Application for a non-material amendment following a grant of planning permission.

<input type="text" value="Single storey front and rear extension first floor side extension, loft conversion incorporating front and rear dormers and linked garage."/>	
Reference number:	<input type="text" value="19/00344/FULL"/>
Date of decision	<input type="text" value="22/07/2019"/>

Remove Front dormer and replace with Velux.
Change porch lean to roof to gable.
New window on flank.
Retention of access gates in current location.

DWG No: EAP540-2

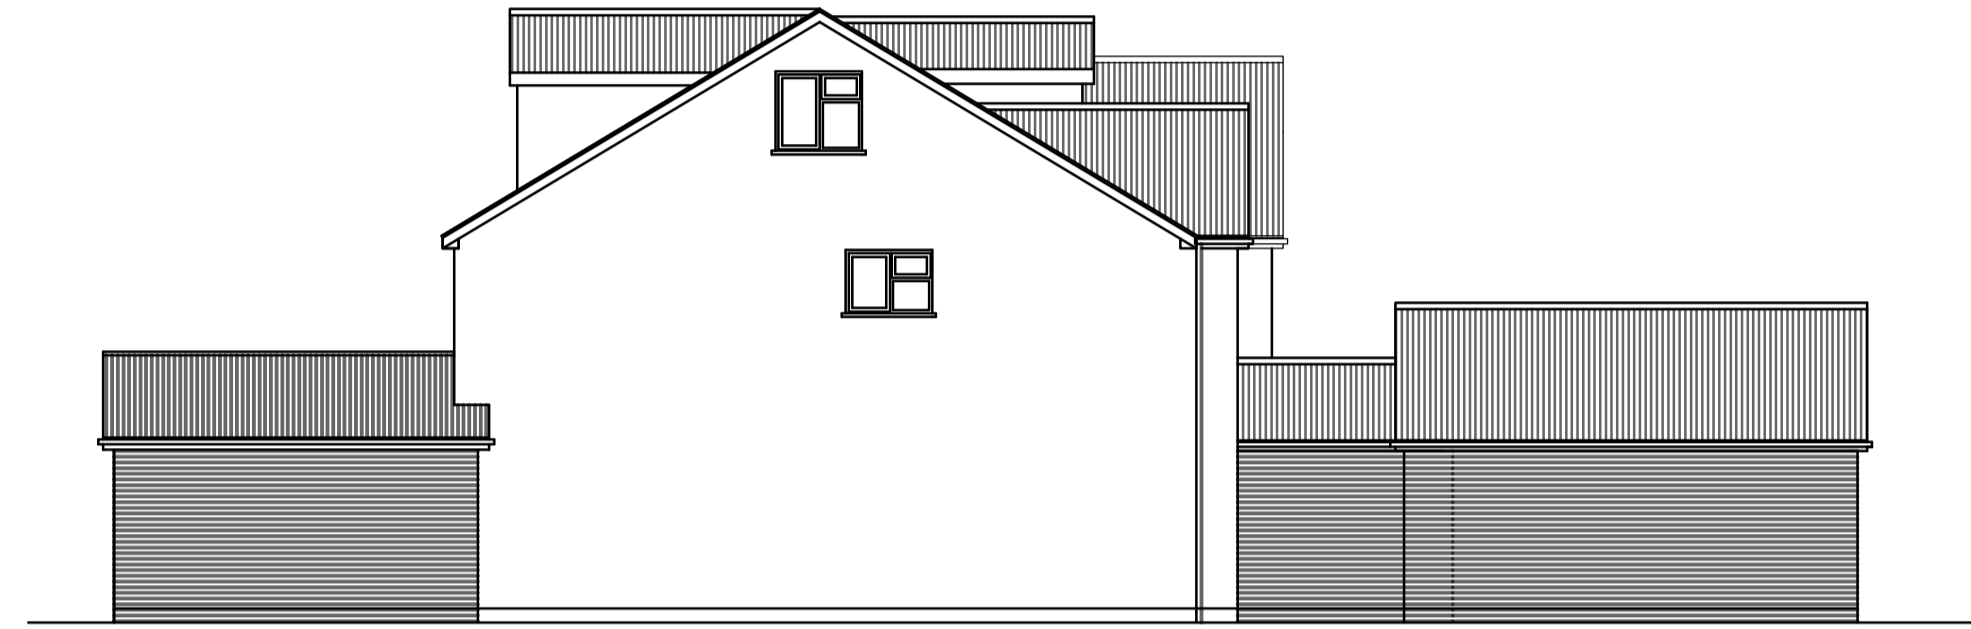
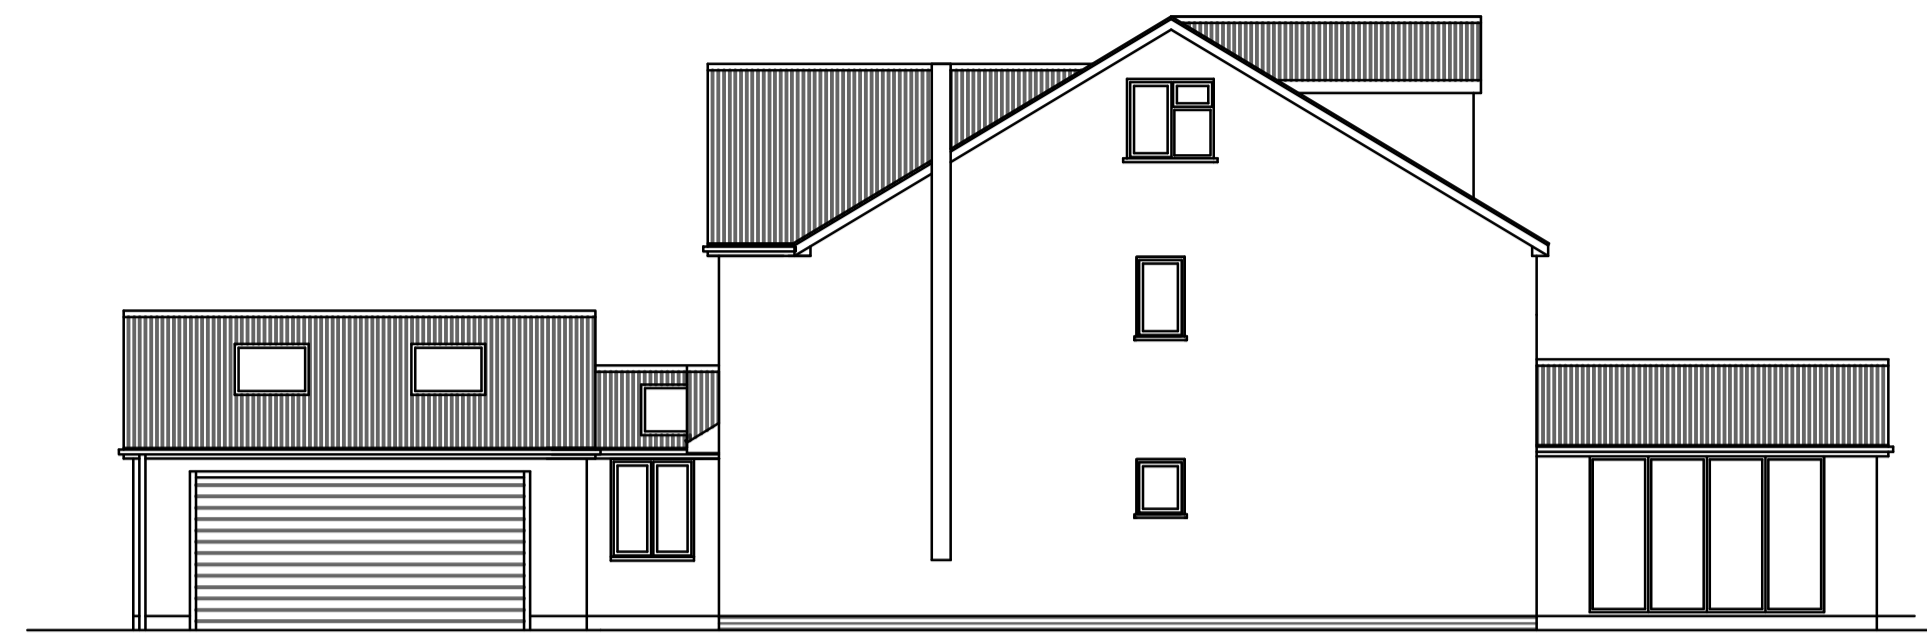
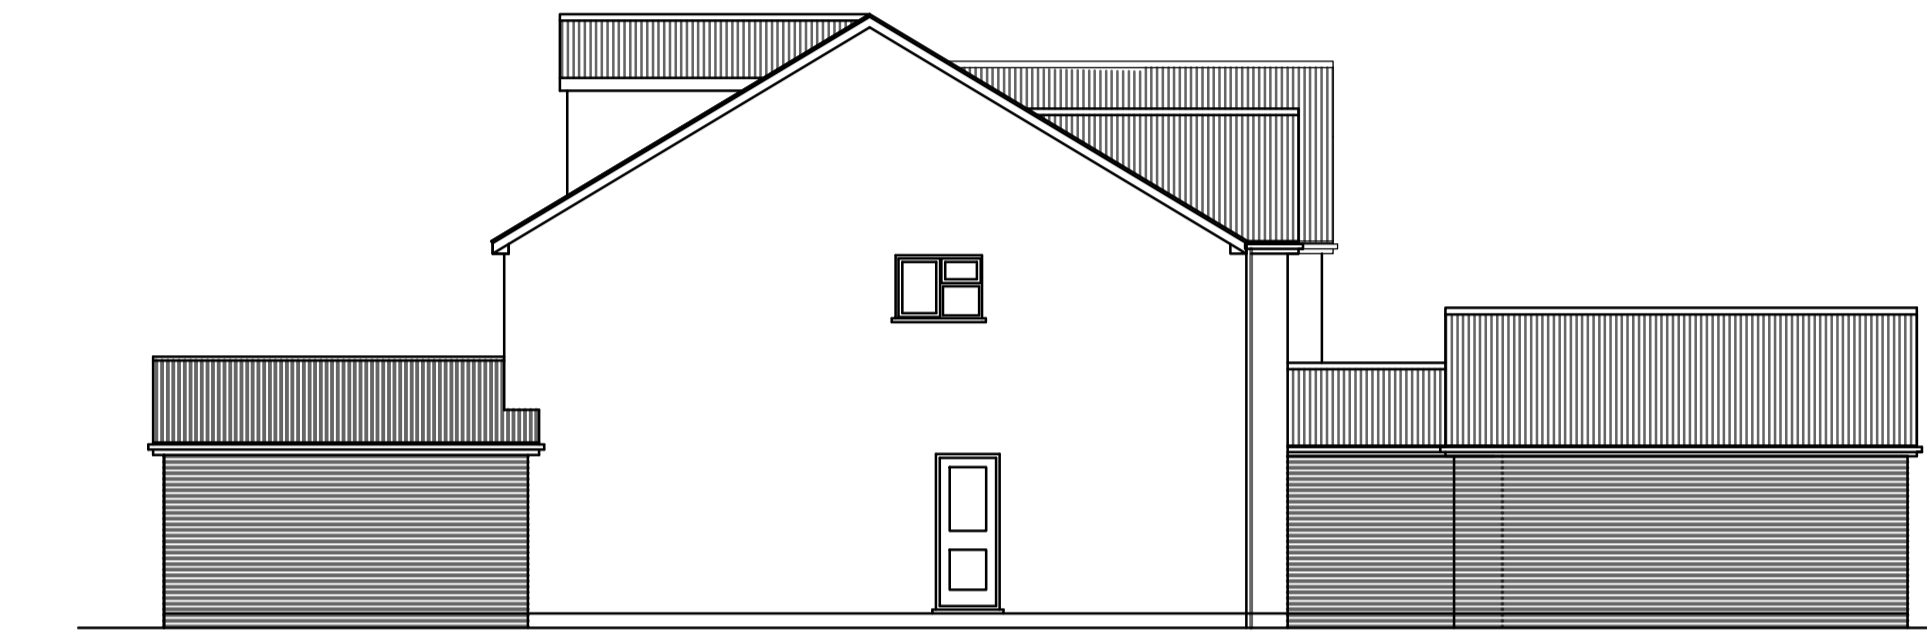
Dormer on front elevation not required, window added to serve en-suite, porch roof changed to match other roof profiles and gate opening retained in current location due to telegraph pole anchor.
